OUT16/34171

**GHD response to DPI's Response to Submissions for Lucas Heights Resource Recovery  
Park expansion project (SSD-6835)**

DPI Water has reviewed the GHD response to DPI's Response to Submissions (RTS) and provides the following comments:

Annexure C - Landscape Plan

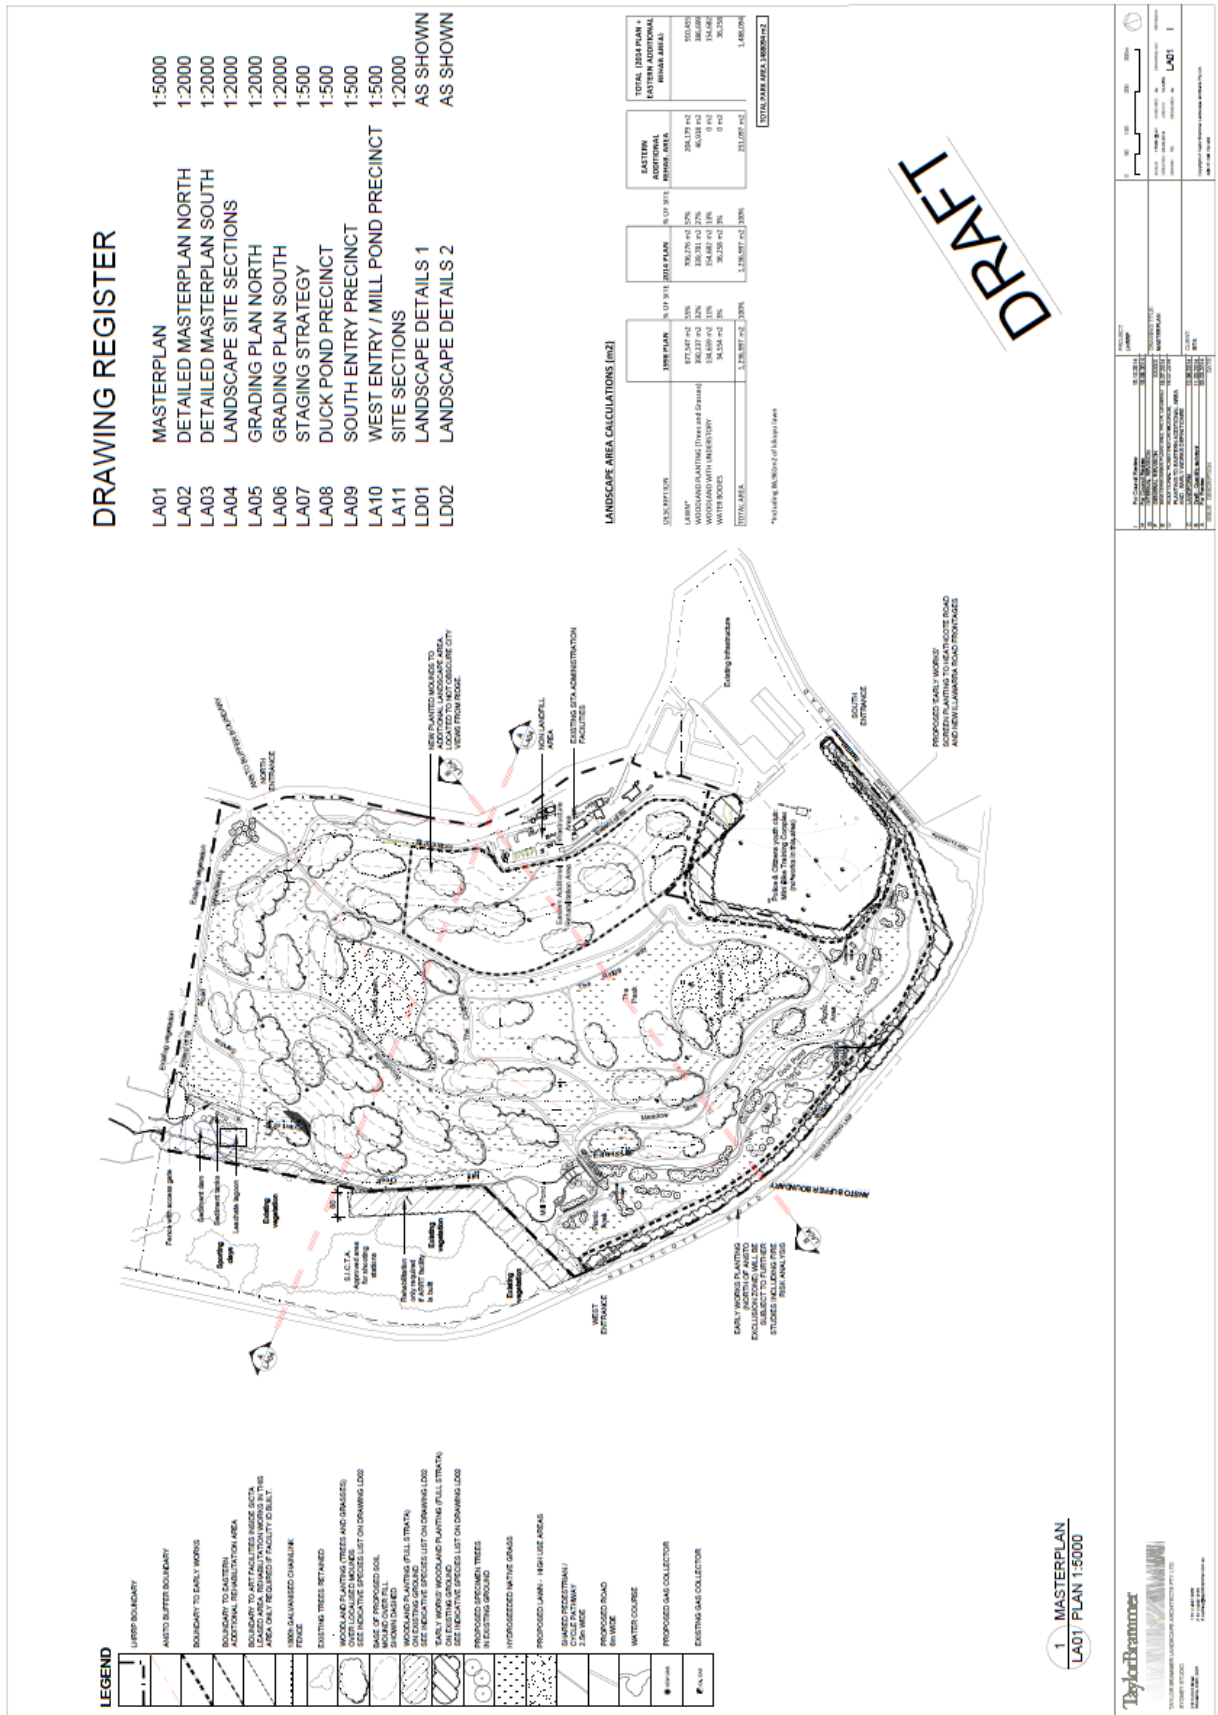
GHD confirms that the project proposes a 10 m wide vegetated riparian zone either side of the creek in accordance with the Guidelines for Controlled Activities on Waterfront Land and the previous plans will be revised to take account of the proposed land use and vegetated riparian zone width. It also notes the plans will consider opportunities to increase the width of the vegetated riparian zone beyond 10 m wherever possible.

The original Development Consent (DA No. 11-01-99) granted by the Minister for Urban Affairs and Planning on 12 Nov 1999, included conditions (107-121) which required a rehabilitation plan to be prepared for the length of Mill Creek on the site. The 2006 Plan that was prepared required a 20 m wide riparian corridor be provided either side of the creek. While the current proposal for a 10 m wide riparian corridor is consistent with [DPI Water Guidelines for Riparian Corridors on Waterfront Land](#), the Department of Planning and Environment should be aware that if the original DA is still in force it may be inconsistent with the current proposal. Any inconsistency should be resolved prior to determination of the project
